Date: 30-Jun-2023
Our Ref: 2023/91555

Discharge of conditions 3 (contamination/presence of coal), 4 (bat and bird boxes), 5 (great crested newts) on previous permission 2022/93143 for demolition of existing storage shed and erection of Animal Centre and associated workshop teaching space at Taylor Hill Centre, Close Hill Lane, Newsome, Huddersfield, HD4 6LE.

**Taylor Hill Centre, Close Hill Lane, Newsome, Huddersfield, HD4 6LE
Application Number: 2023/91555**

Figure 1. Development Plan

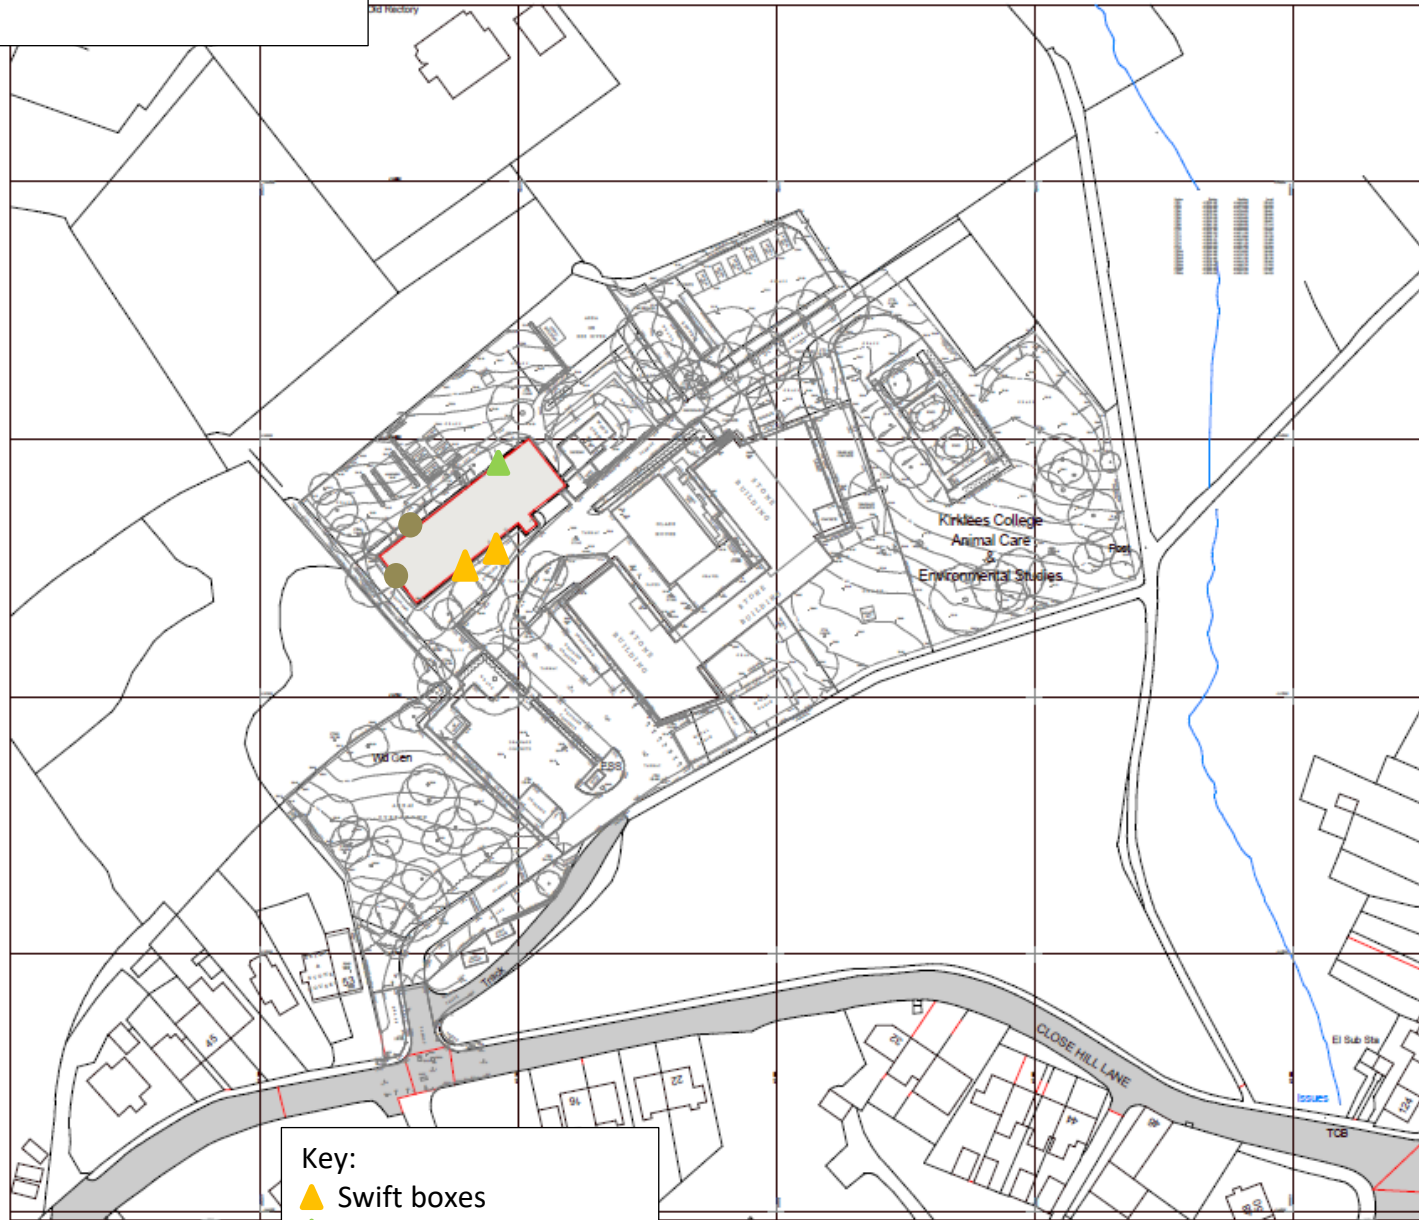
I can confirm that the submitted details are acceptable, although it is noted that the condition does have an ongoing requirement in that these boxes and terraces are to be installed prior the first use of the building and once installed shall be retained for the lifetime of the development.
